NorthConnex Application Number: SSI 13_6136

Please find below my submission in response to the exhibition of the EIS for NorthConnex.

Figure 5: NorthConnex Longitudinal Section including Wahroonga Precinct

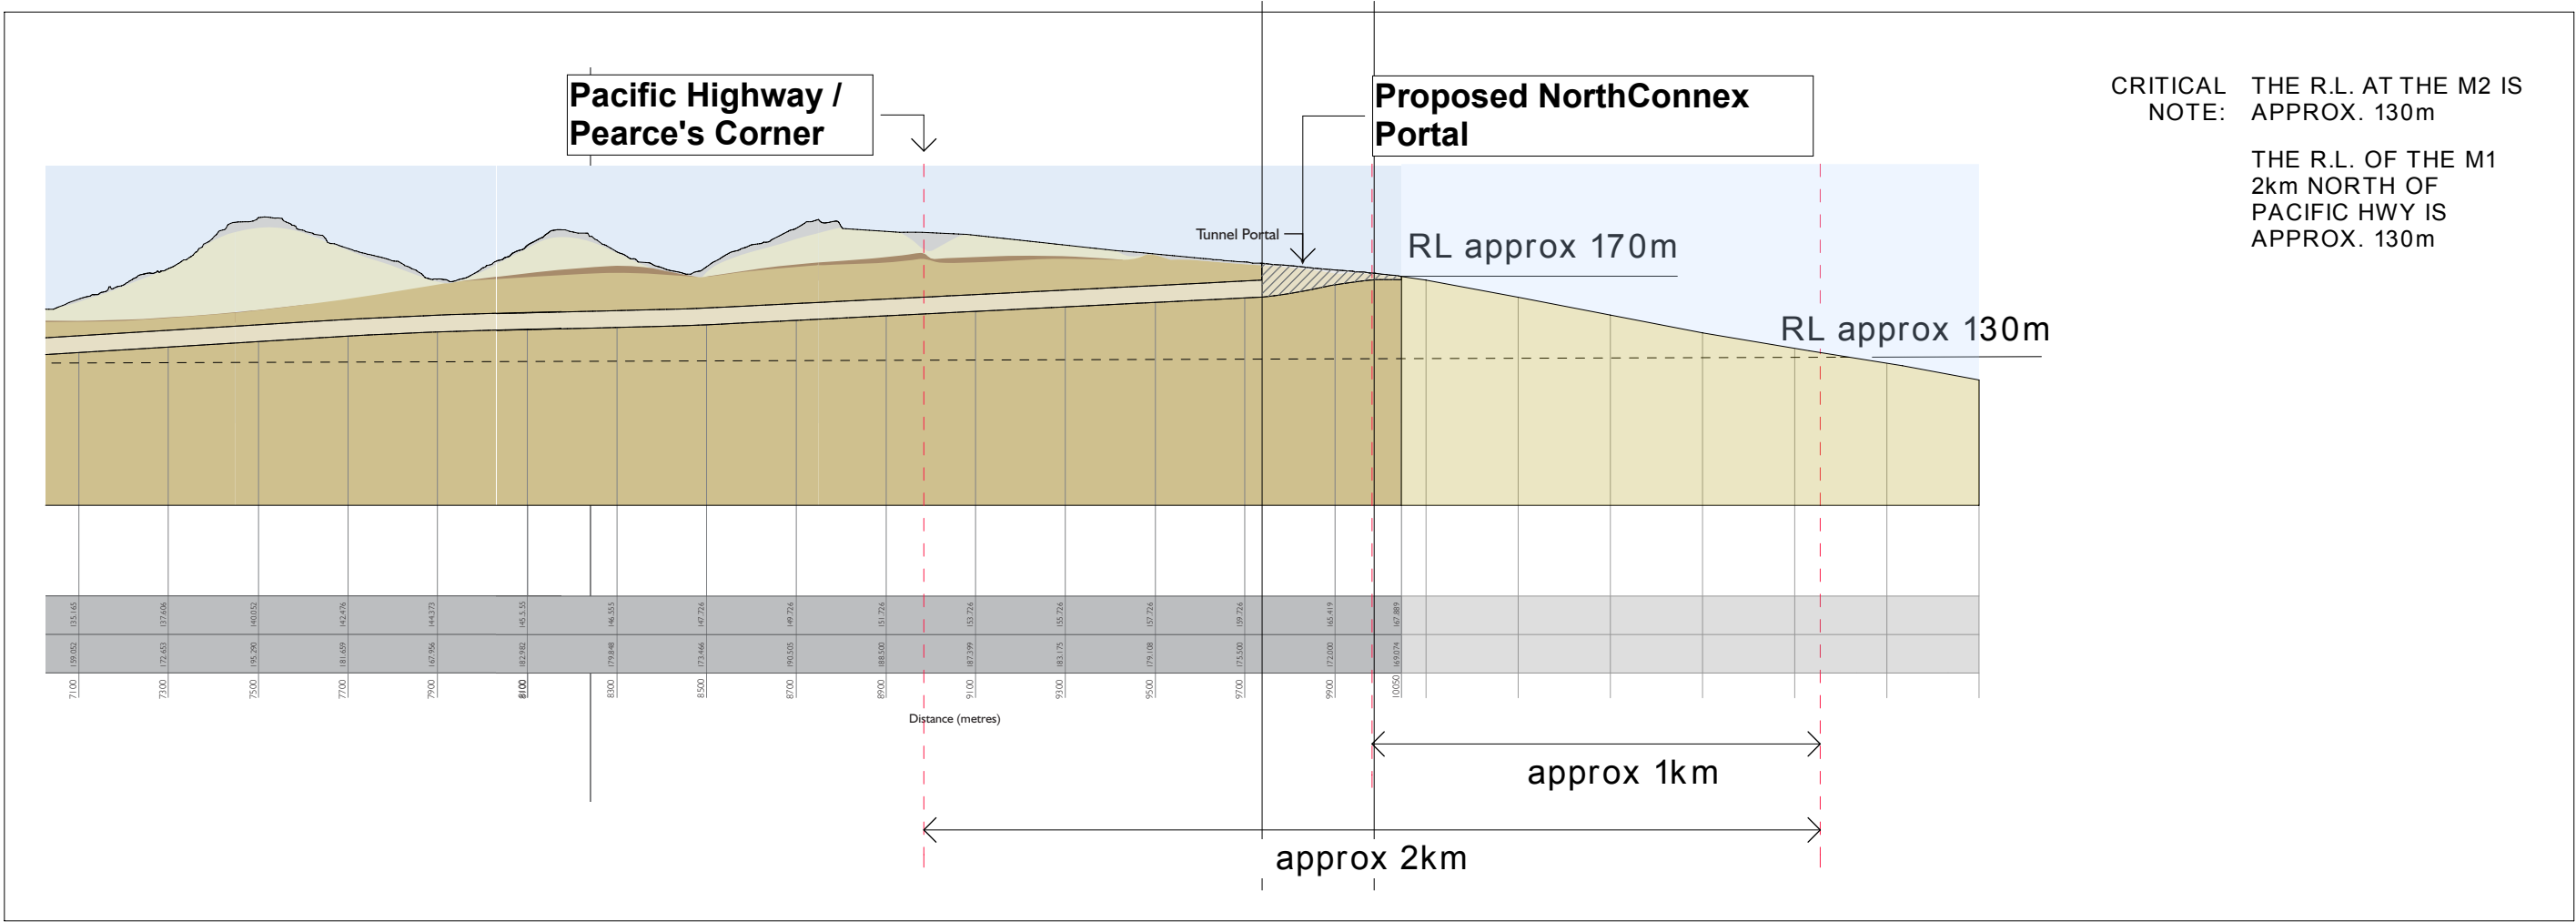
5. The proposed design causes an unnecessary gradient within the tunnel, meaning that heavy vehicle engines will be required to work harder, causing more pollution at the northern ventilation stack. Alternate designs have been proposed which allow for a flatter tunnel, eliminating this issue.

Figure 20: Perspective of northern ventilation facility located in Wahroonga heritage precinct.

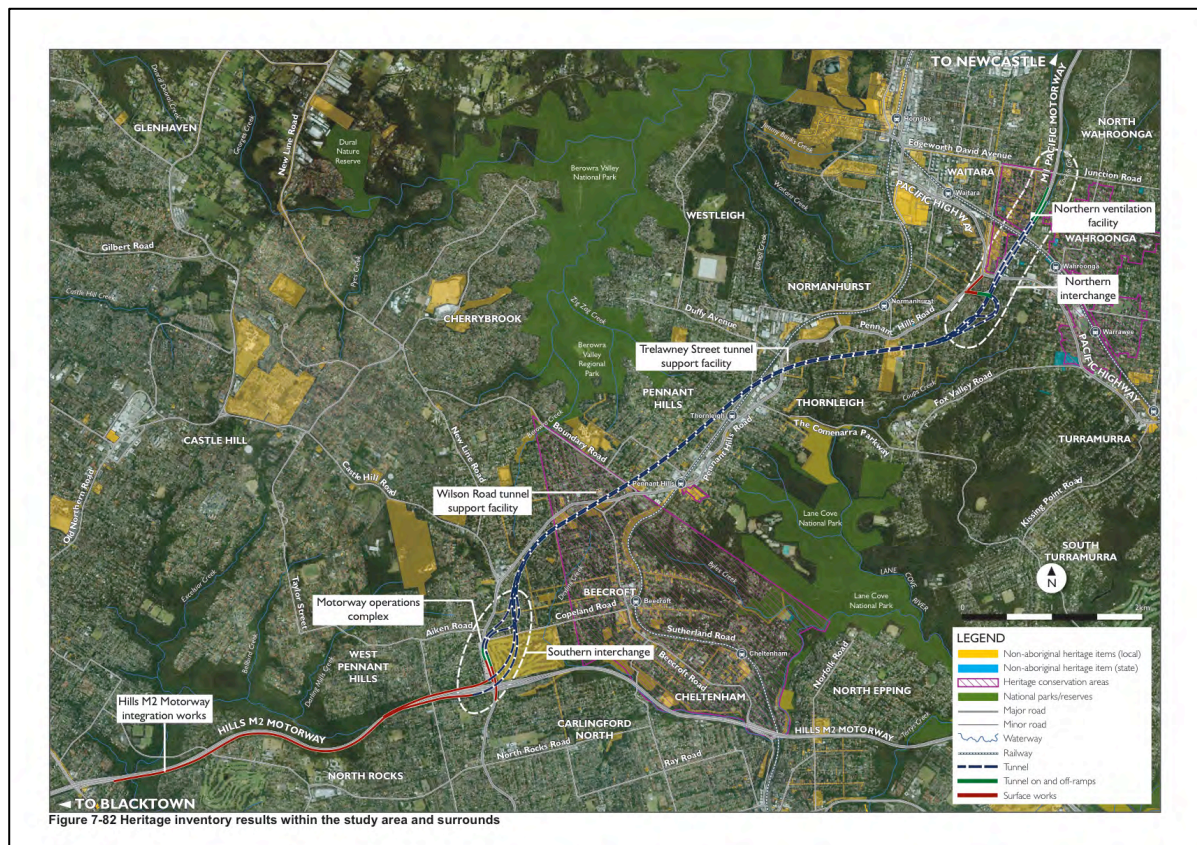
2. Placement of the northern ventilation stack in the centre of a densely populated residential area in Wahroonga, where 9,300 school children will be exposed, as well as multiple aged care facilities, hospitals, businesses and homes. A simple look at a map will make it obvious that there are plenty of alternate sites where the ventilation stack and portal could be situated, away from such a densely populated residential area. To the north the M1 passes through large amounts of national park and the Hornsby industrial area.

3. The height and placement of the proposed northern ventilation stack in a valley in Wahroonga where there are often low wind speeds, which will result in poor dispersion and exposure of community to high levels of tunnel emission. The stated height of the stack only brings the exhaust level with the playing field at Waitara Public School, which my children are required to attend. The following images shows the relative height of the proposed northern stack vs the height of the Cross City Tunnel stack in Pyrmont. (Note that the Cross City Tunnel is orders of magnitude shorter)

1. The air quality and human health impact assessment need to be revised to address the issues raised above.
2. An independent options assessment process should be undertaken to assess alternative locations for the tunnel design, ventilation stack and portals. This includes the CAPS submission and others.
